Jeanie Bourke - Re: 30 Salem St., BP#2015-00709 - Revision 2

From: Clifford Tremblay <cliff.tremblay@gmail.com>
To: Jeanie Bourke <JMB@portlandmaine.gov>
Date: 5/28/2015 12:49 PM
Subject: Re: 30 Salem St., BP#2015-00709 - Revision 2
Attachments: A1 Graef Wintergarten.pdf

Thank you for the details and the revised plan. I do have some additional comments for you to address:

WINTER-GARTEN PERMIT

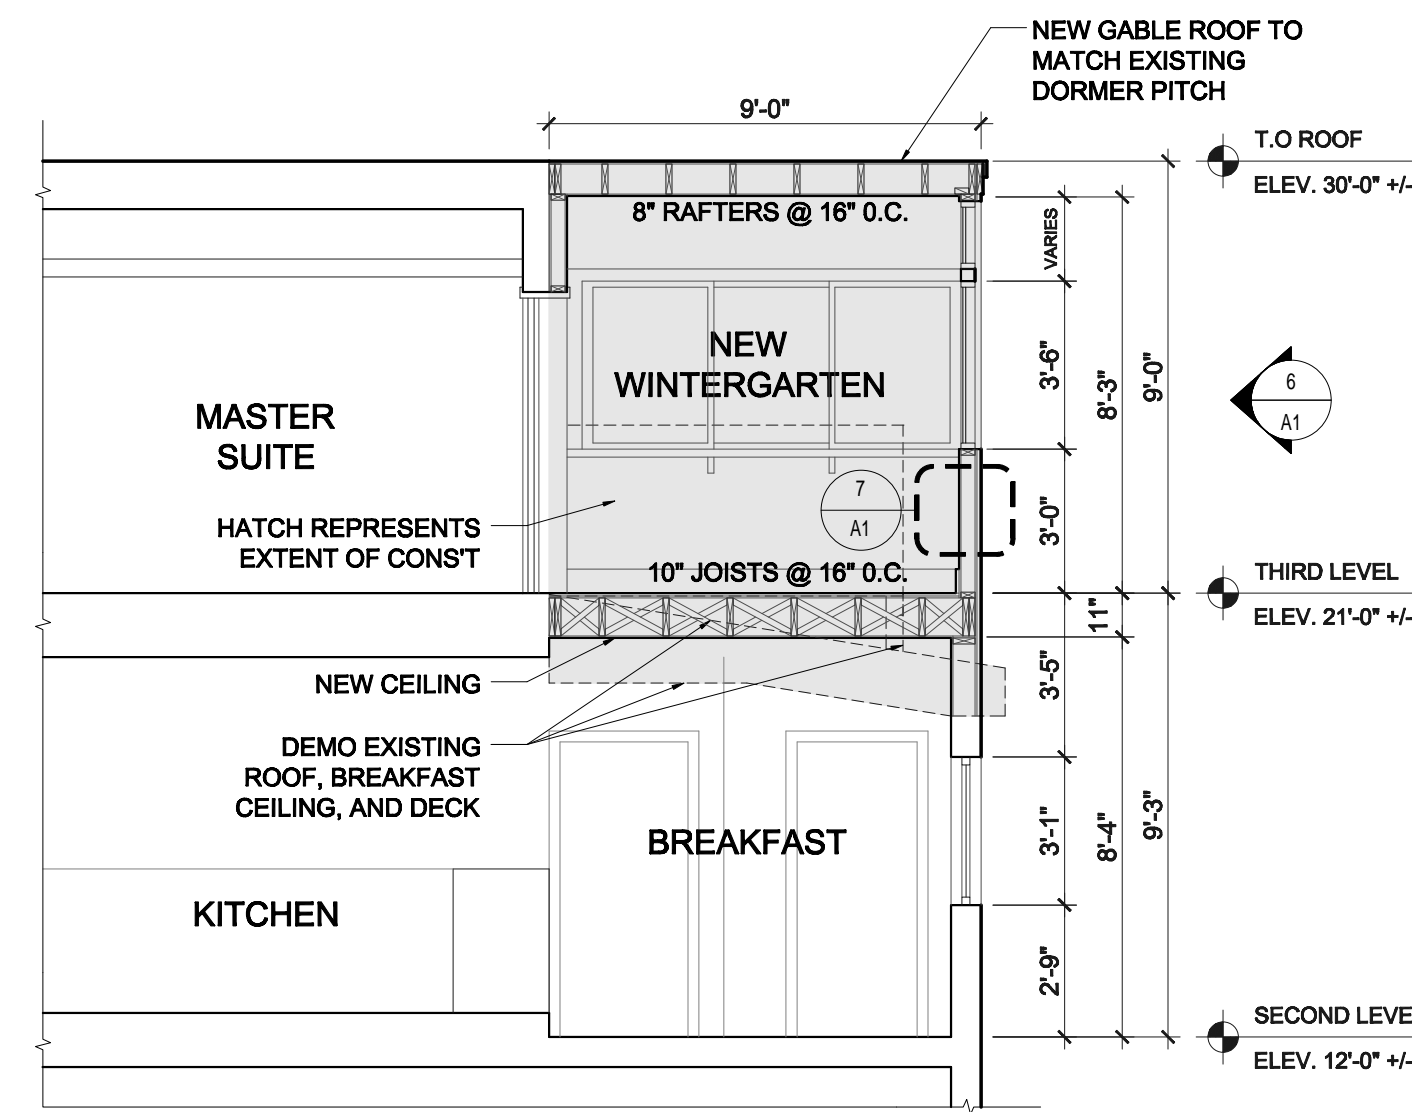
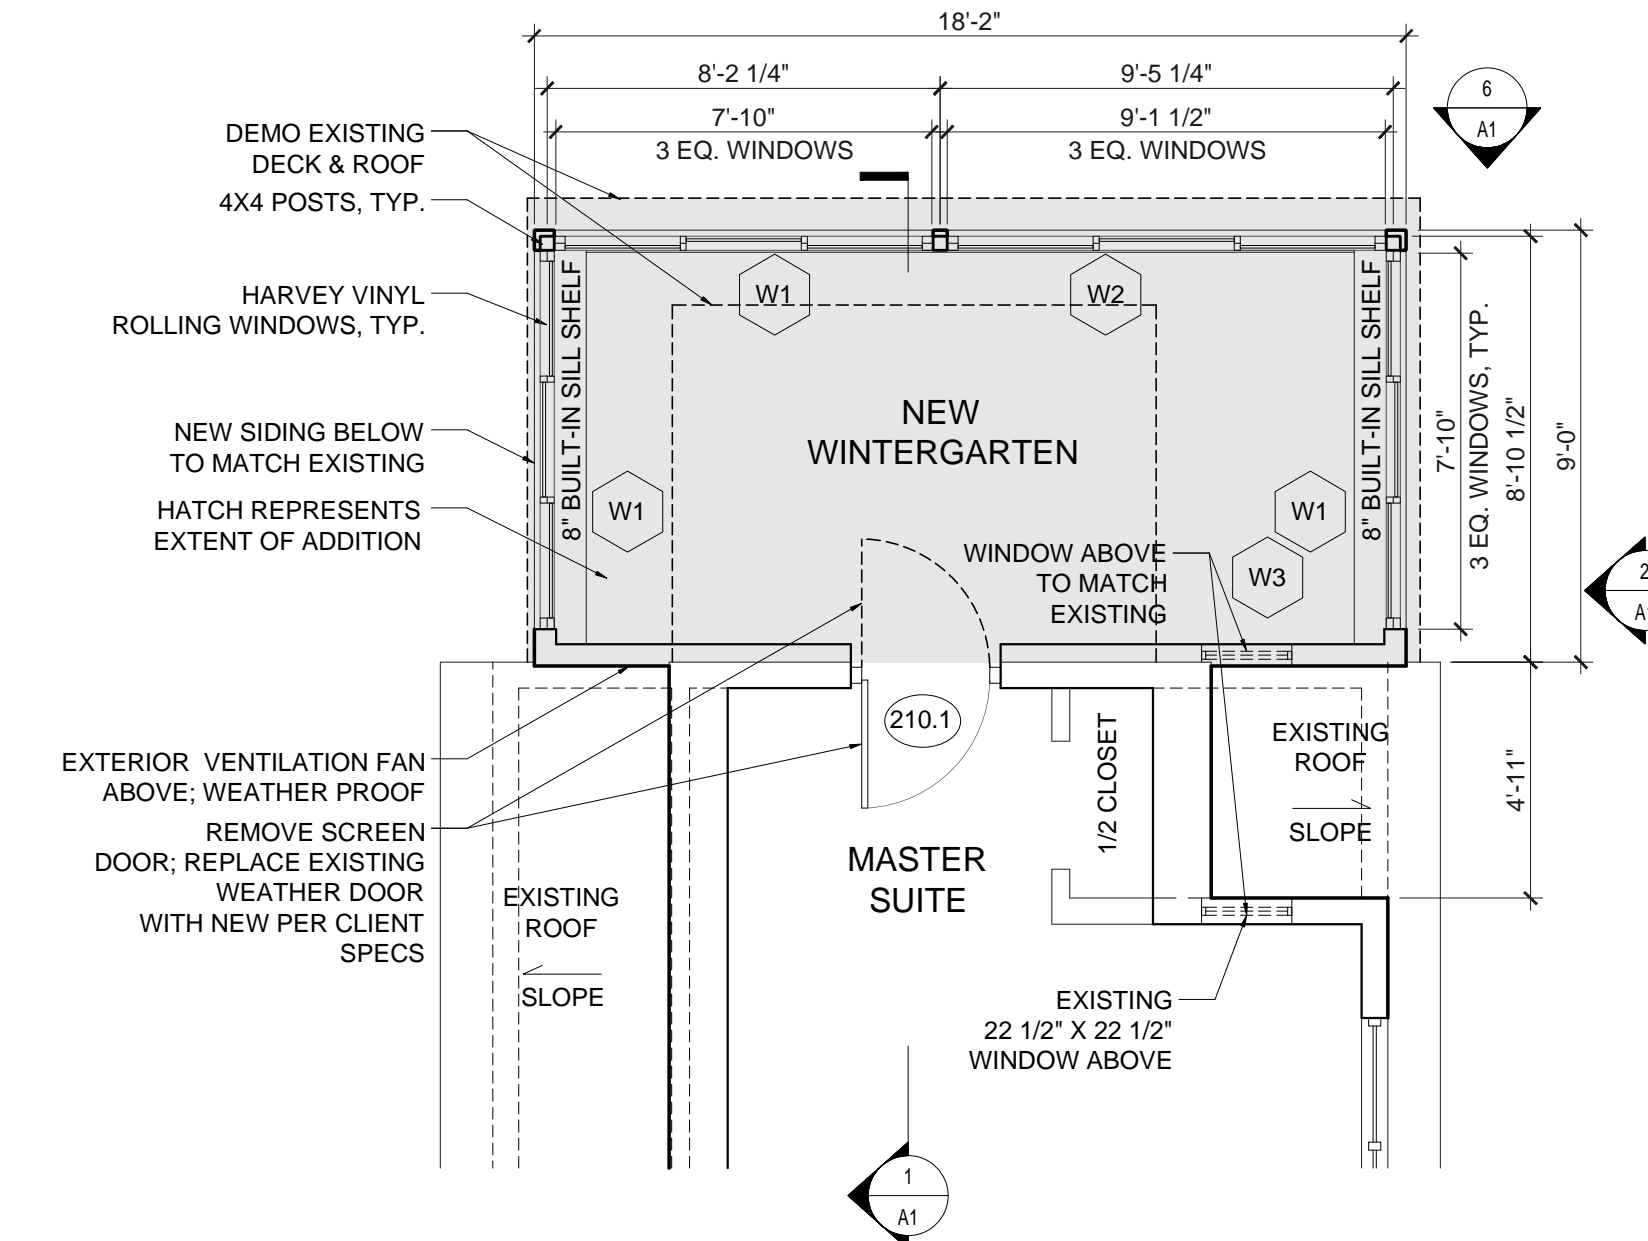
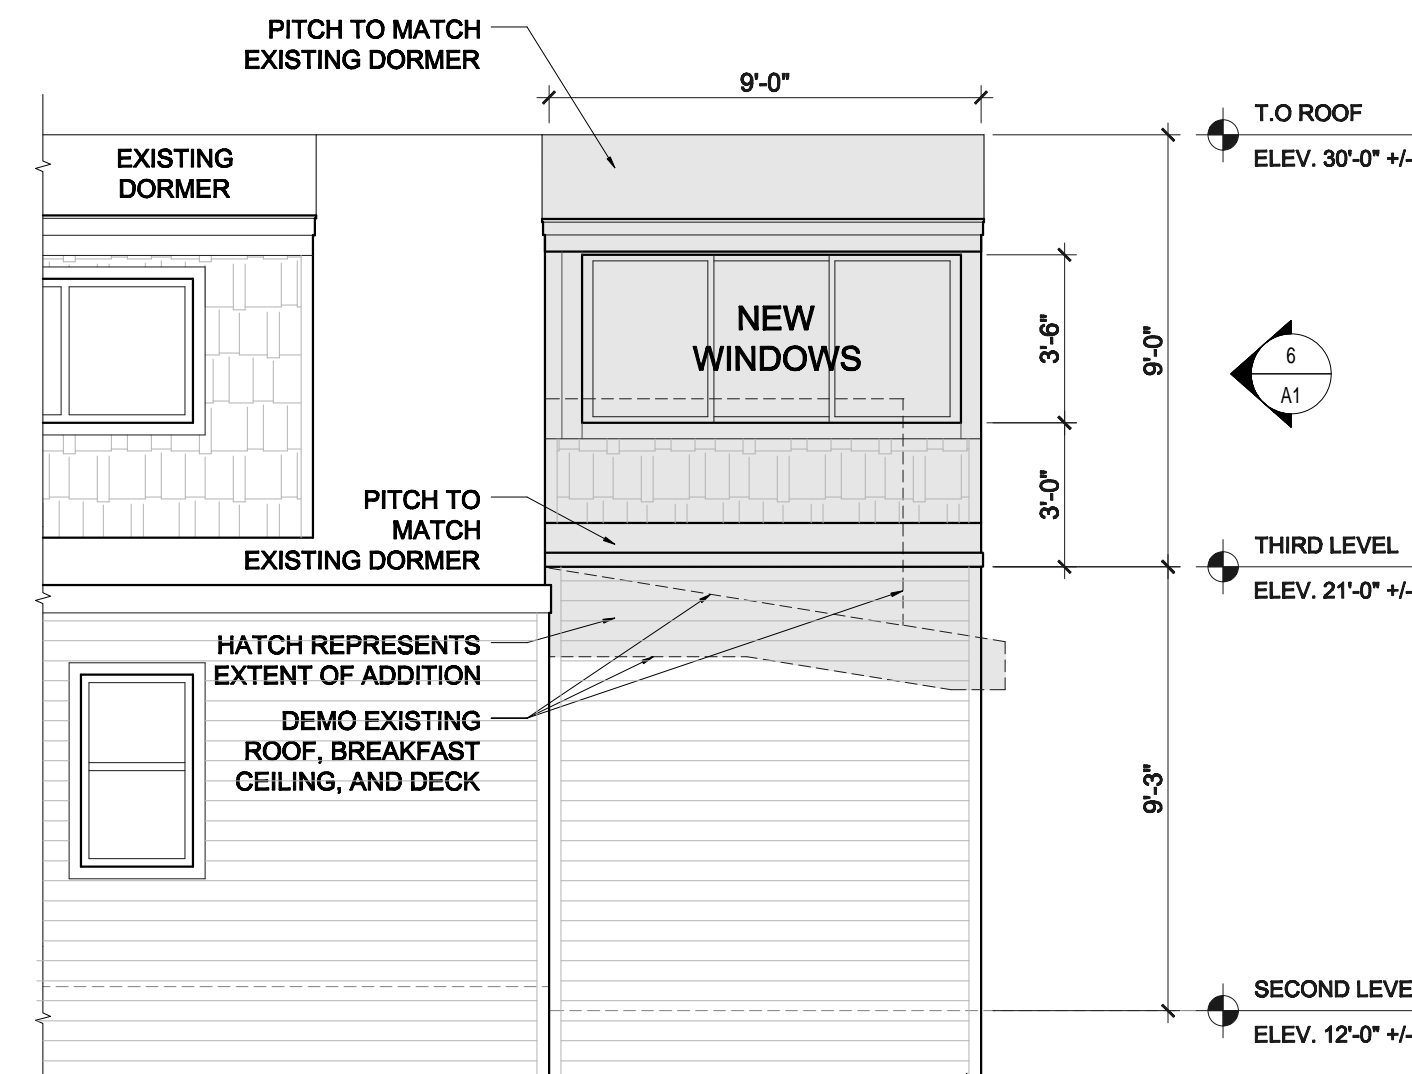
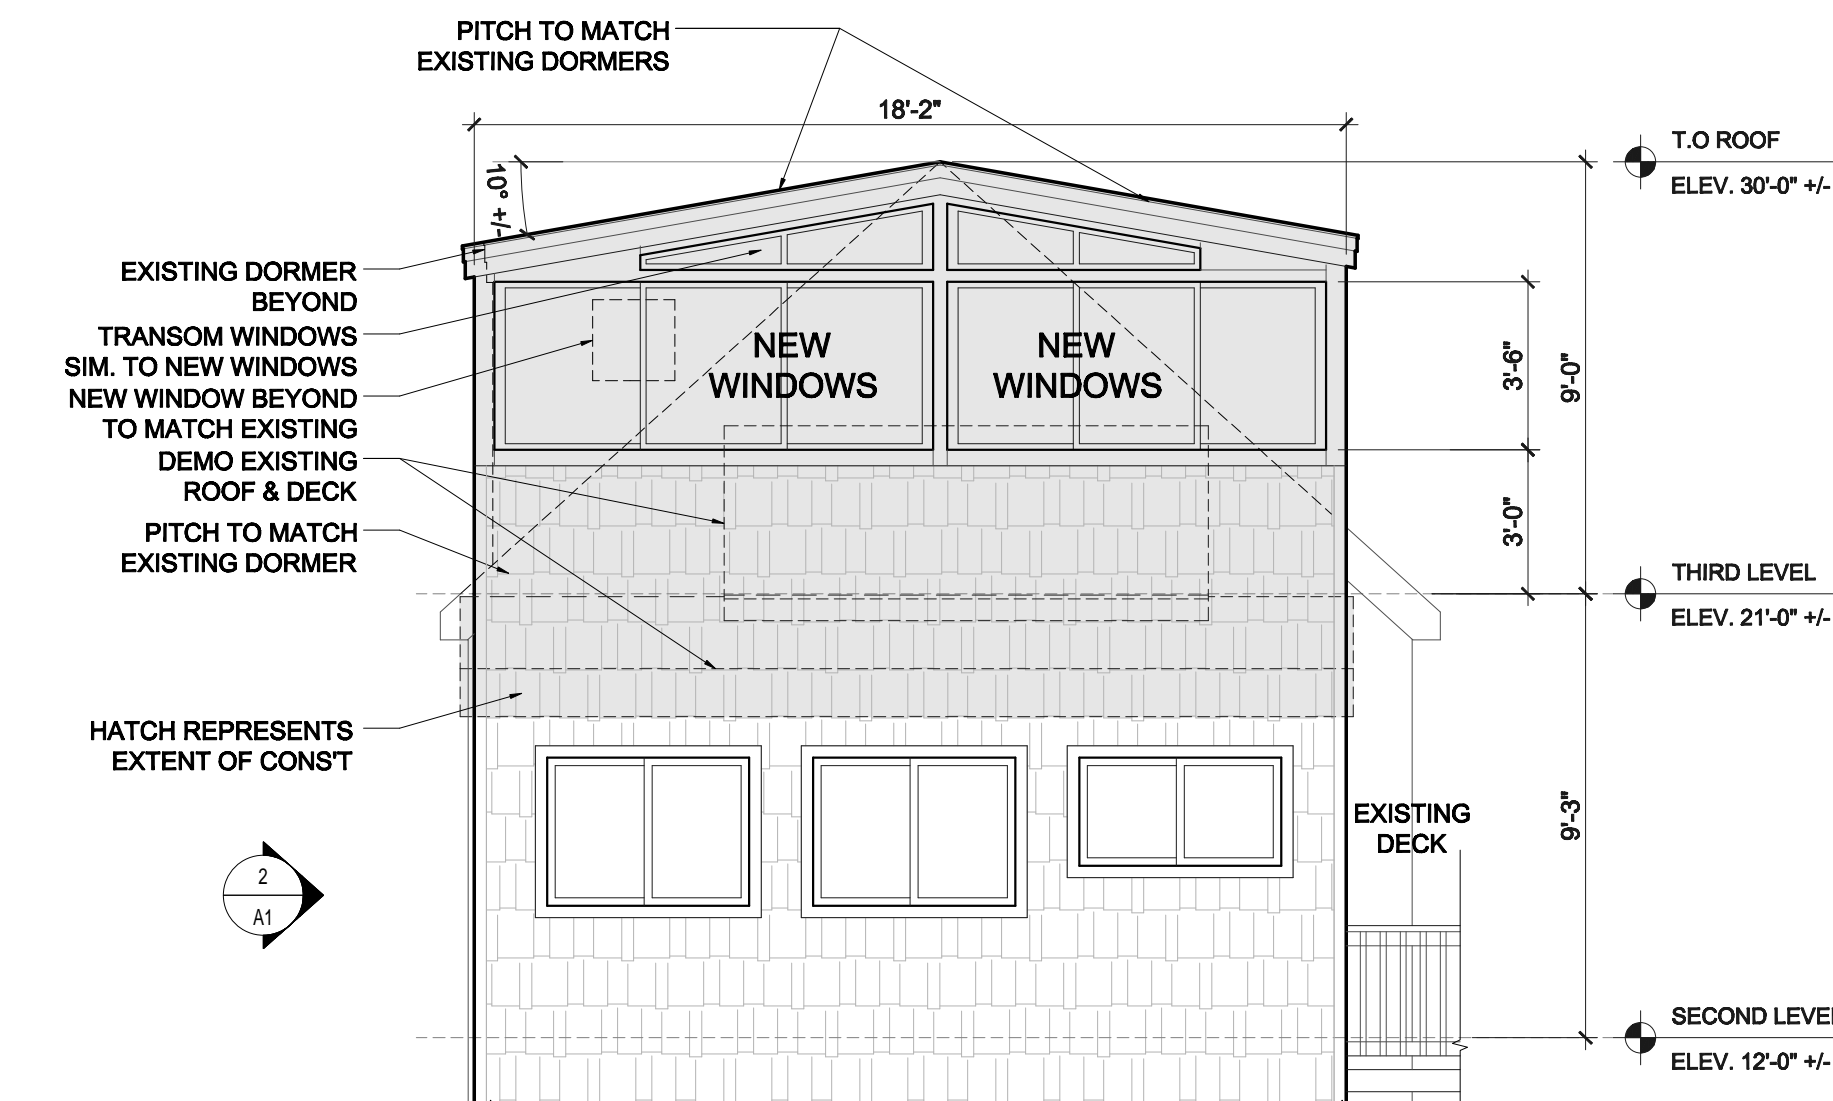
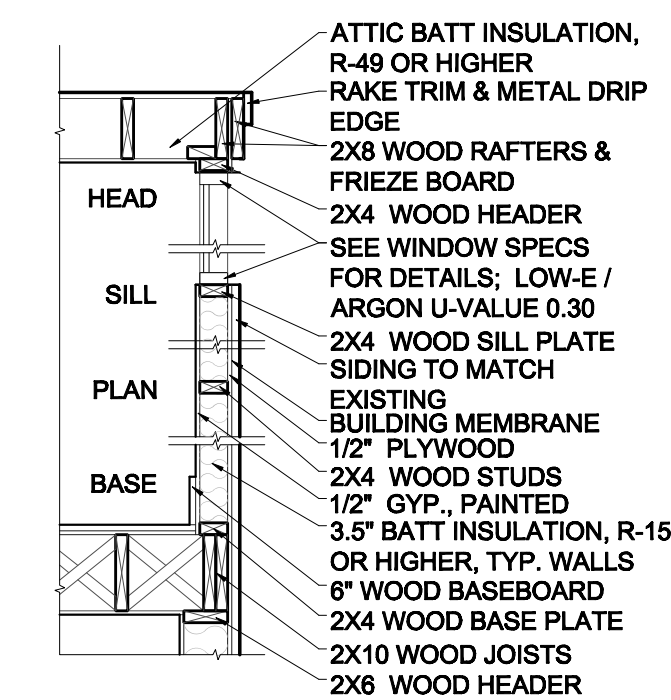
1. Due to this roof being a cathedral with no rafter ties, the ridge will need to be a structural beam, it appears you are showing a single 2x8. There will also need to be additional connections noted at the ridge and the wall for lateral stability.

2. If you plan to heat (condition) the room, the wall insulation is a minimum of R20, usually achieved with 2x6 construction or other insulation products.

3. The bearing wall headers over the windows will need to be larger than 2-2x4 members. Please see IRC Table 502.5(1) for a 50lb snow load. The span looks to be about 8', which would require either 2-2x10 or 3-2x8.

4. The longitudinal floor bearing wall below will need a minimum of 2-2x6 top plate (header noted on your plan), or if single will need to specify the joist bear over each stud and additional tie in with steel plates at the corners and the joists land directly over the stud below.

Using a 2-ply 3.5 x 9.5 LVL beam and added notes for the positive connections at the beam and at the headers.

Good point! We enlarged the walls to handle this larger insulation.

Using 3-2x8's with 1/2" plywood laminated between to achieve the thickness of our enlarged 2x6 walls.

Using 2-2x6 top plates.
